Cherwell District Council
Planning Division
Bodicote House
White Post Road
Bodicote
Banbury
OX15 4AA

PLANNING PORTAL REF: PP-12274002

APPLICATION TO DISCHARGE CONDITION 13 OF PLANNING REF: 19/02948/F – LAND SOUTH OF SOUTH SIDE, STEEPLE ASTON.

Condition 13 – Landscaping

scheme: Land south of Southside, Steeple Aston, Oxon  
client: Rectory Homes  
drawing: Soft Landscape  
date: Apr. 2021  
scale: 1:250@A1  
drawing no: REC23270-11B  
drawn: JNT checked: JS

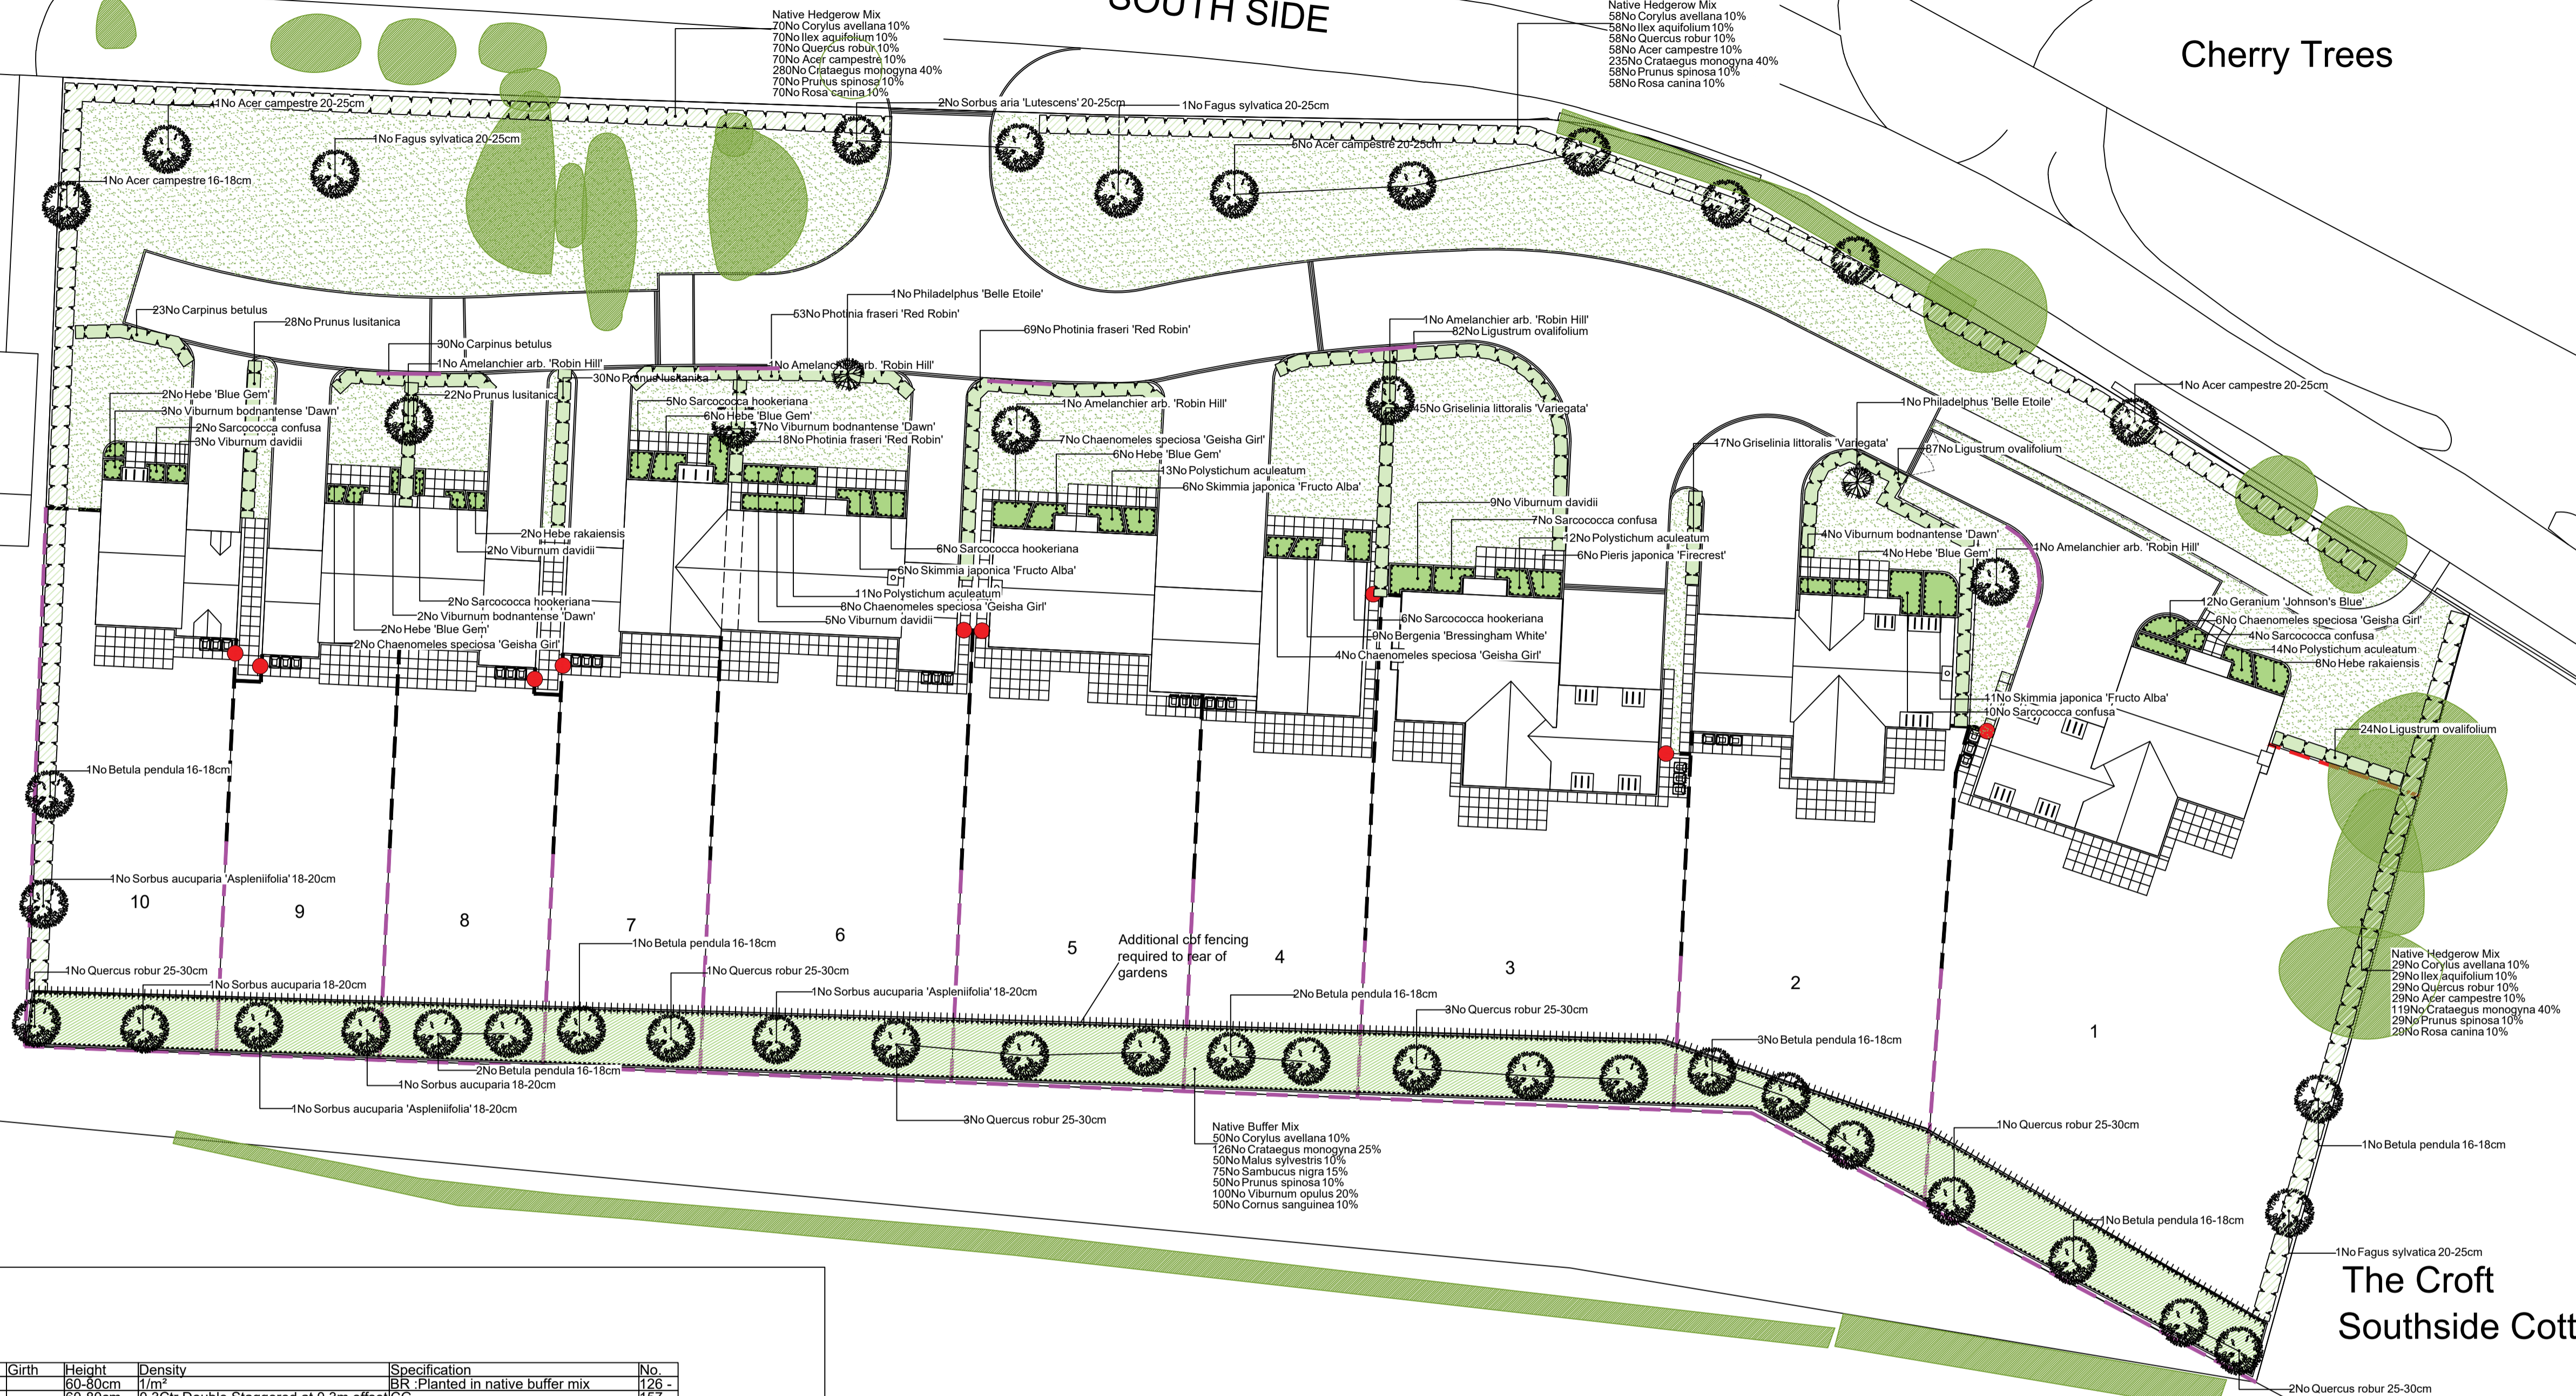
- Replacing the 1.2m high estate railings proposed along the footpath north of plot 1 to 1.2m high post and rail fencing;
- Omission of the hedge between the footpath north of plot 1 and the driveway;
- Deletion of the 1.2m high estate railings proposed to define the front curtilage between plots 1 and 2 and replace with low-level hedge;
- Planting of a new hedge along the boundary treatment to the east of plot 1.

The hedge originally proposed between the footpath north of plot 1 and the driveway has been removed from the plans as there is not sufficient space between the boundary fencing and the curb-line of the driveway to plant the hedge.

The post and rail fencing reverts back to the boundary treatment originally indicated on the Materials Plan (ref: P.224.MP.01 Rev K) approved as part of the detailed planning permission under application reference 19/02948/F.
